RE: Planning Application: FG/198/16/PL : 1 Sea Drive, Ferring

RE: Planning Application: FG/198/16/PL : 1 Sea Drive, Ferring

With reference to the above planning application and our subsequent telephone conversation, please find attached a copy of the updated plans revised in accordance with our discussions.

TITLE: PROPOSED PLANS

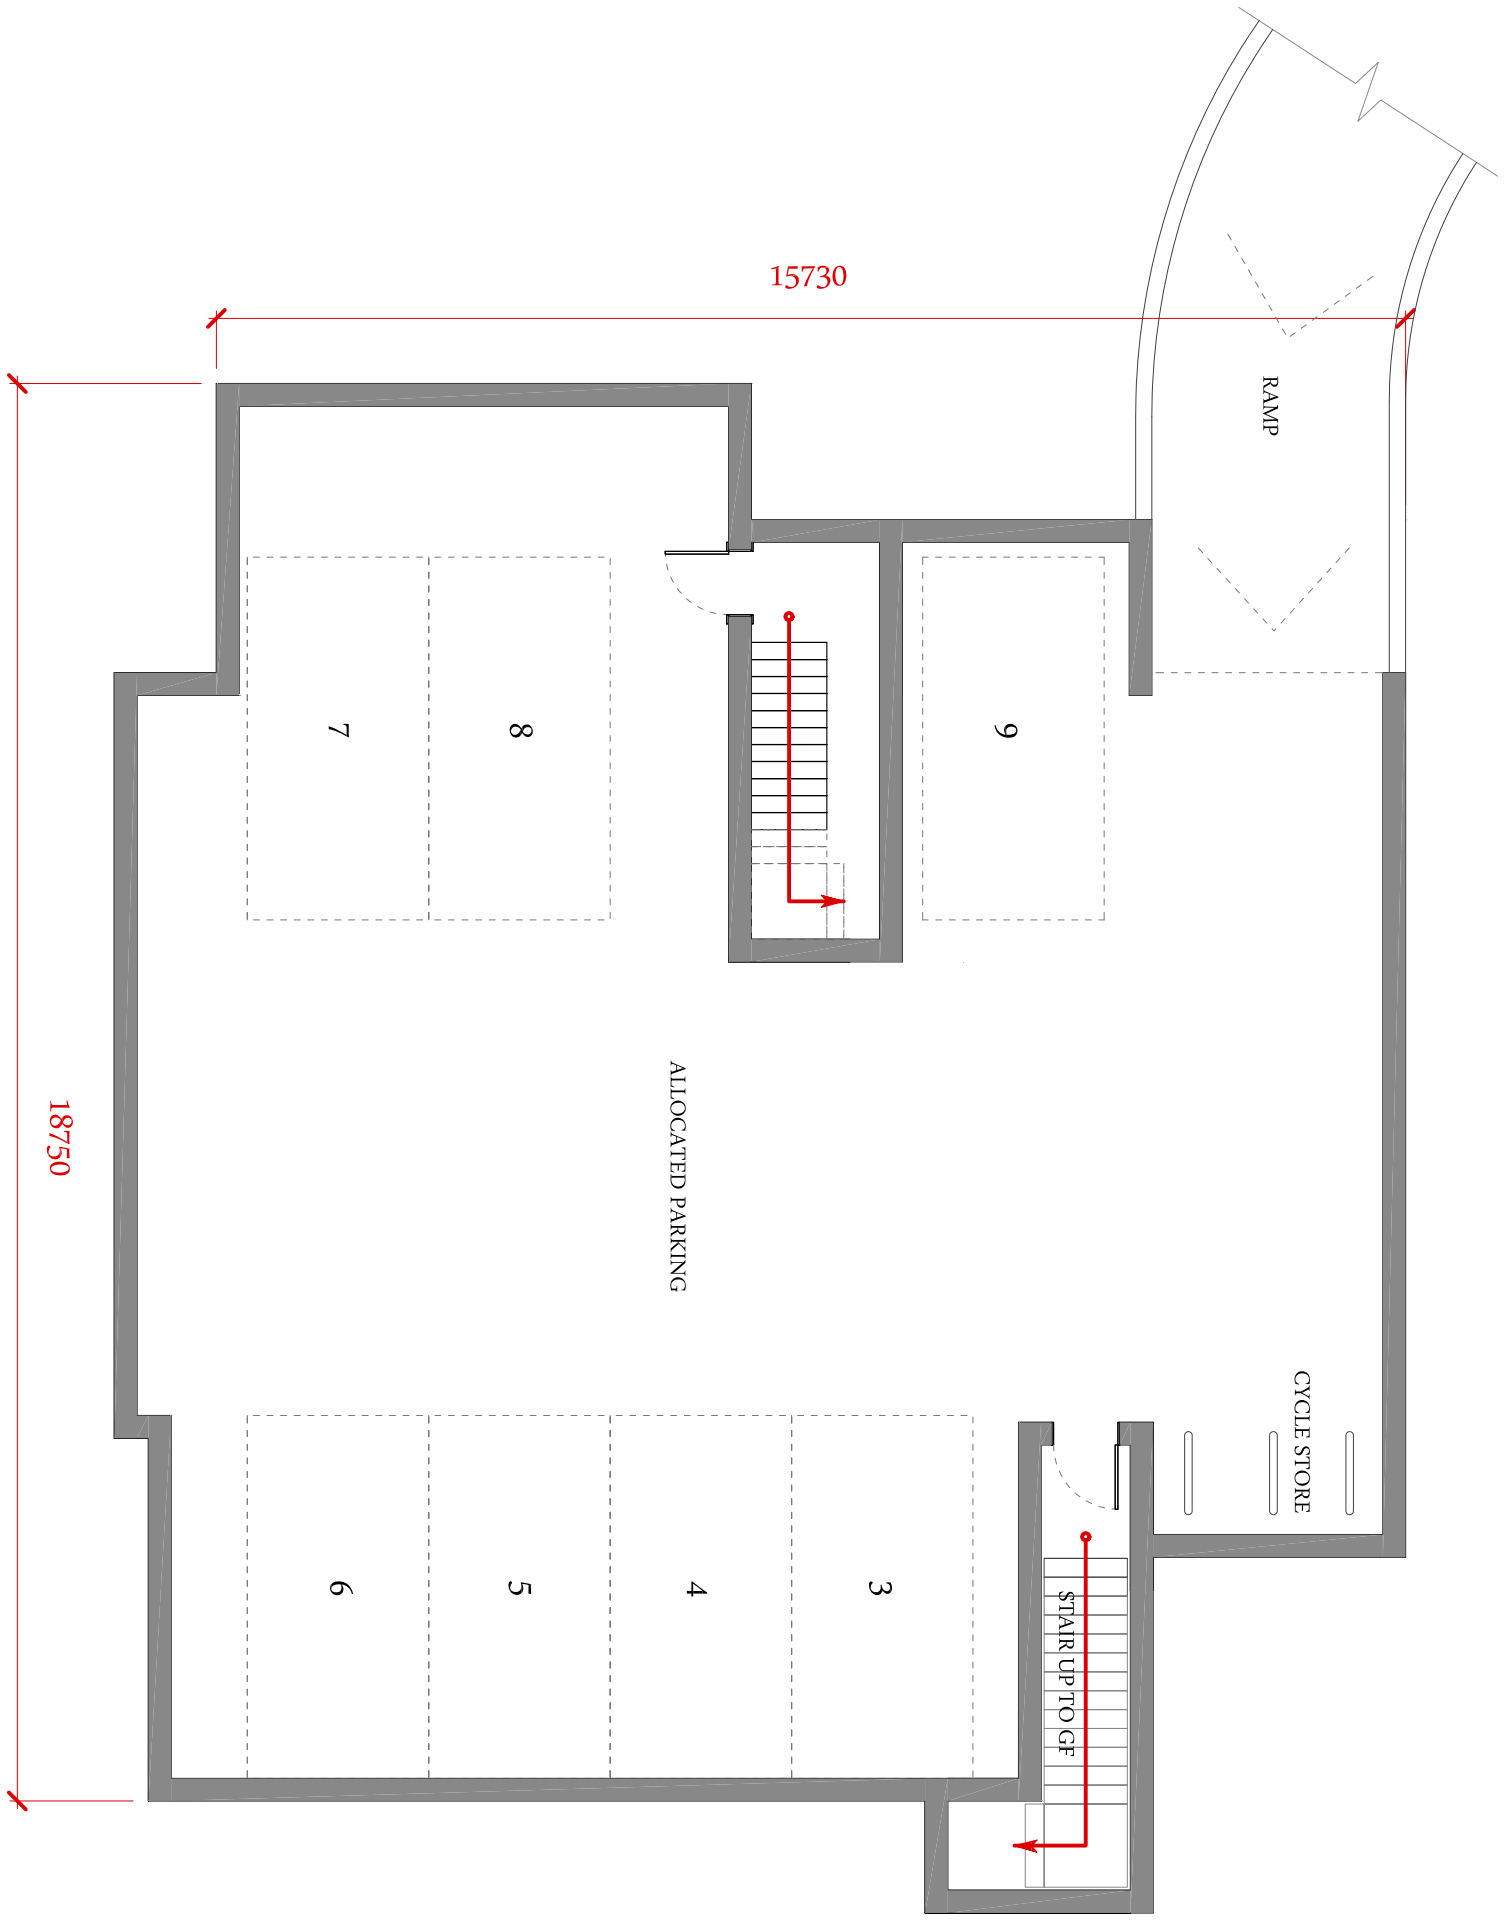
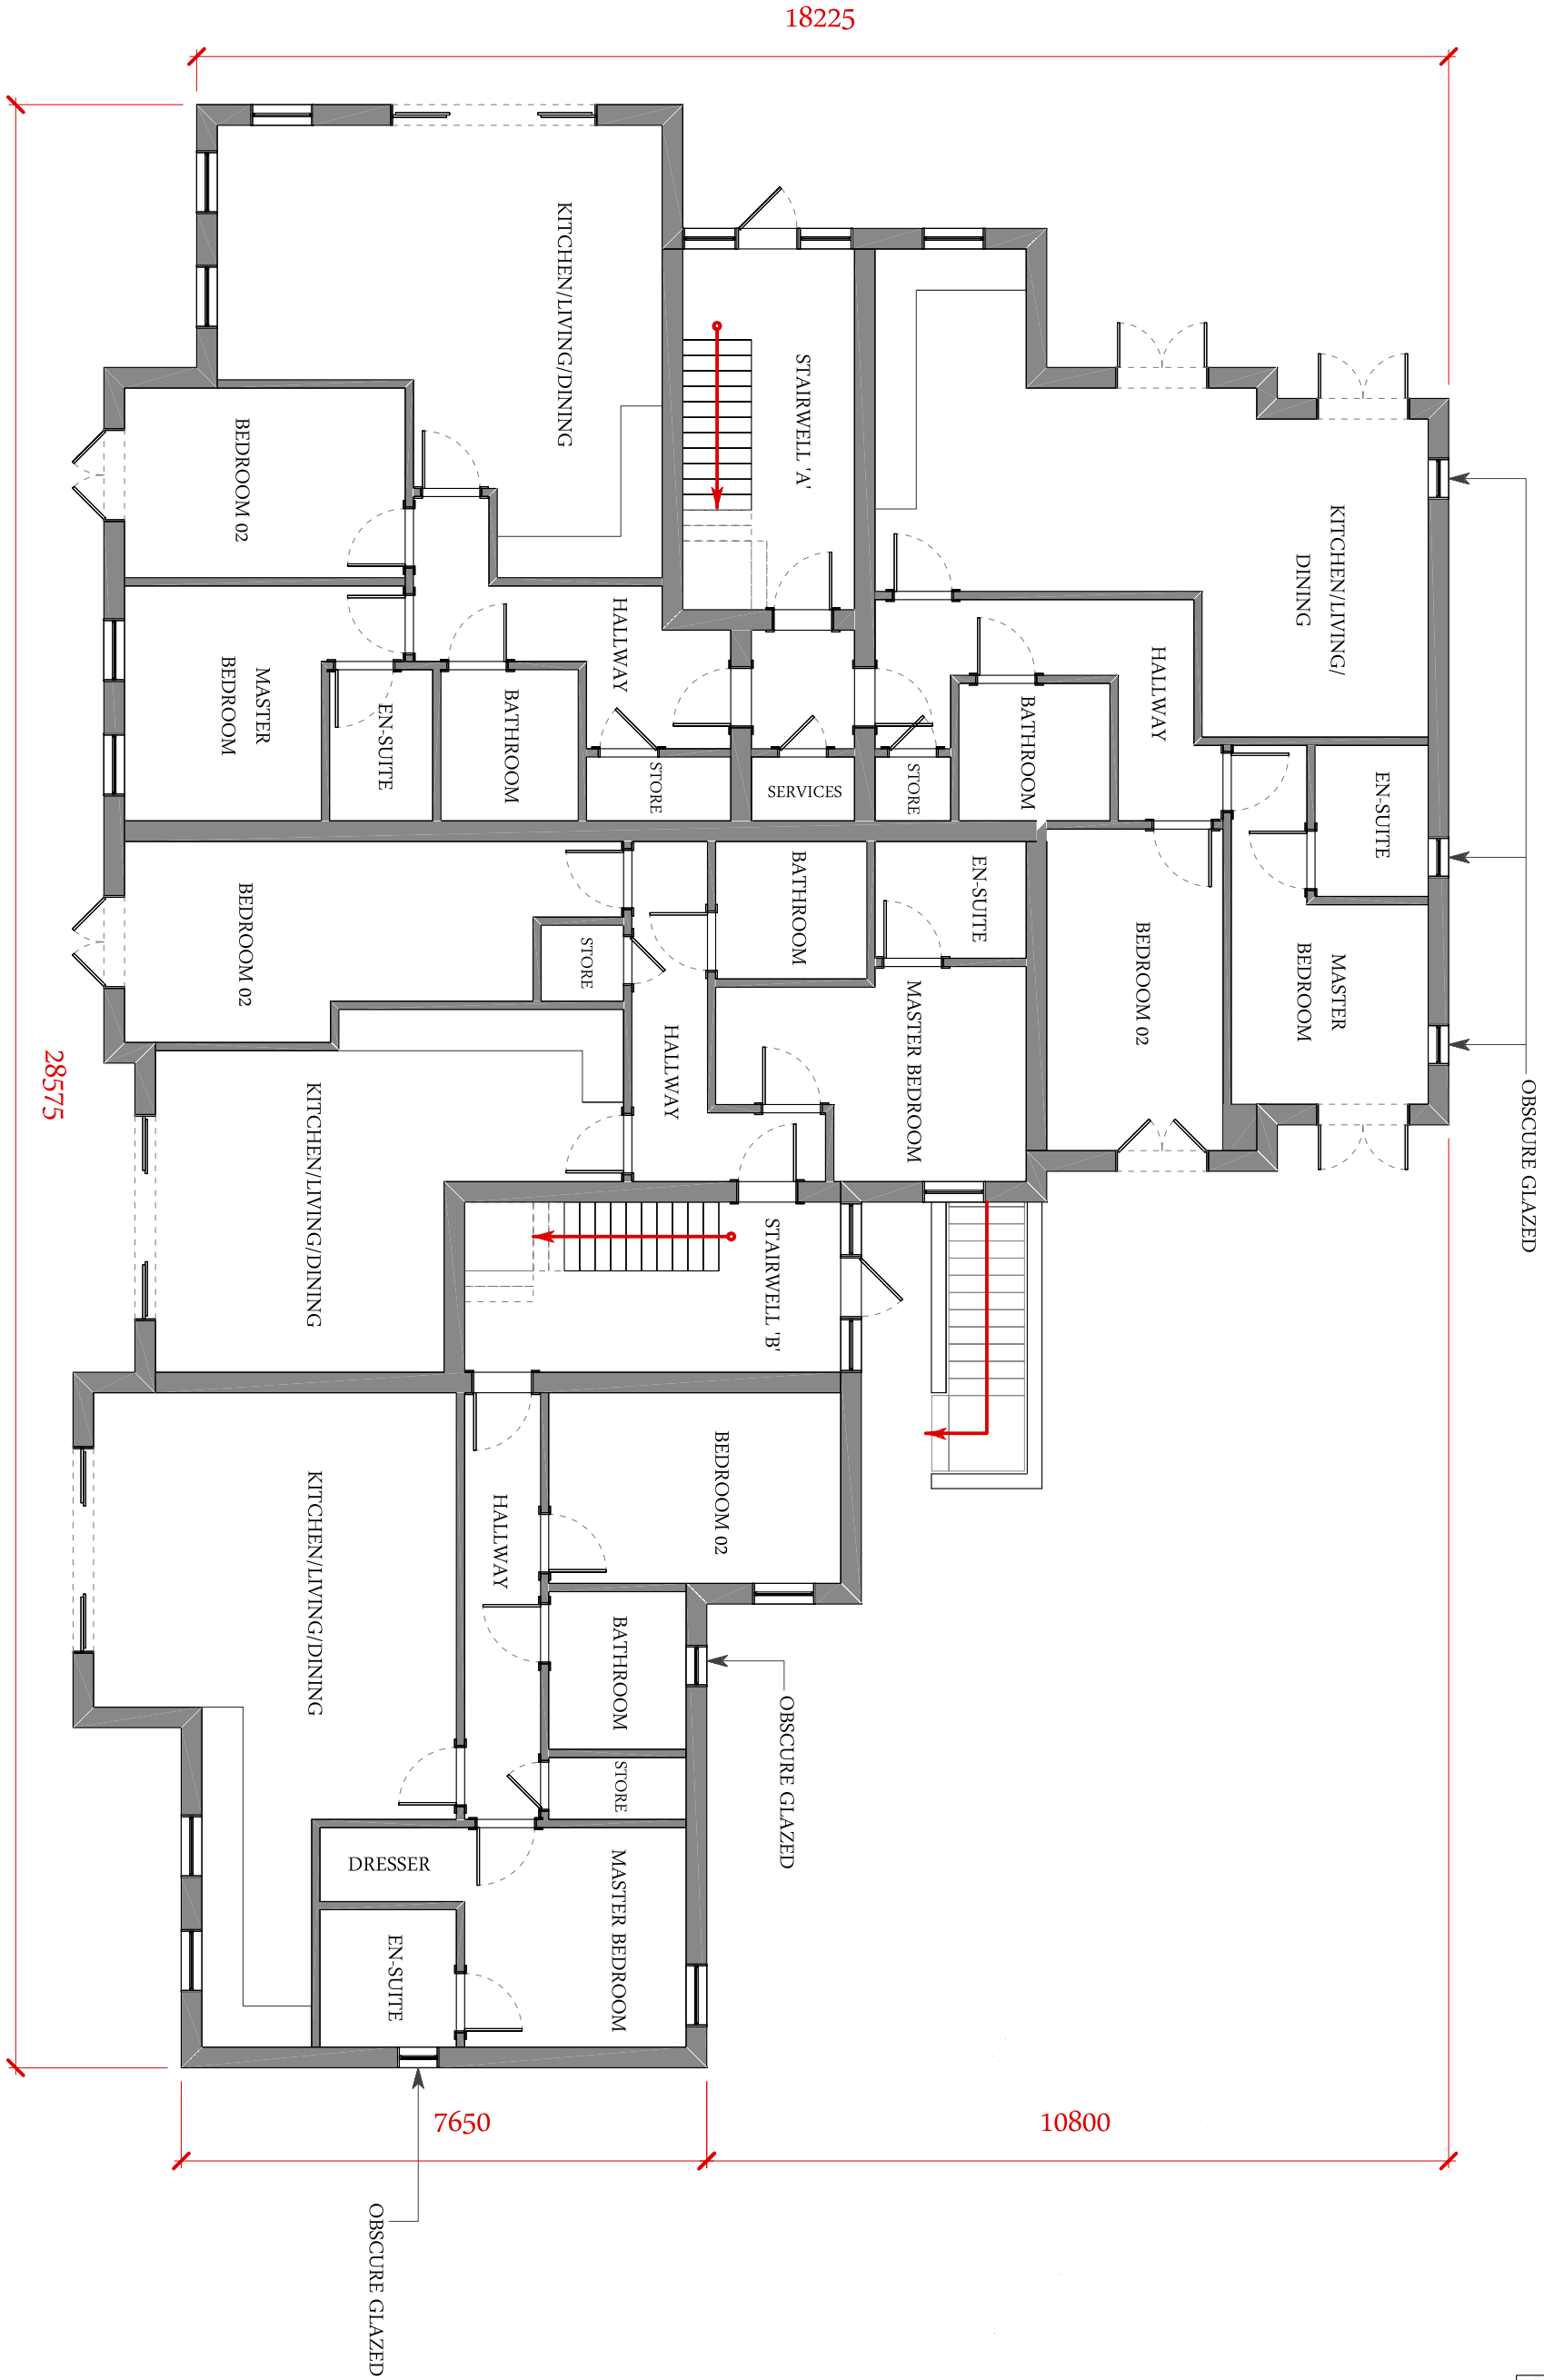
1. Introduce basement parking; we have achieved 8no parking spaces within the basement via a ramped access from the rear and 2no spaces above ground, total 10no parking spaces.
2. Reduce above ground hardstanding to enable increased soft landscaping to the boundaries adjacent to neighbouring properties.
3. Introduce low wall & railings with hedging to Sea Lane/Sea Drive frontage to match 'Blue Waters'.
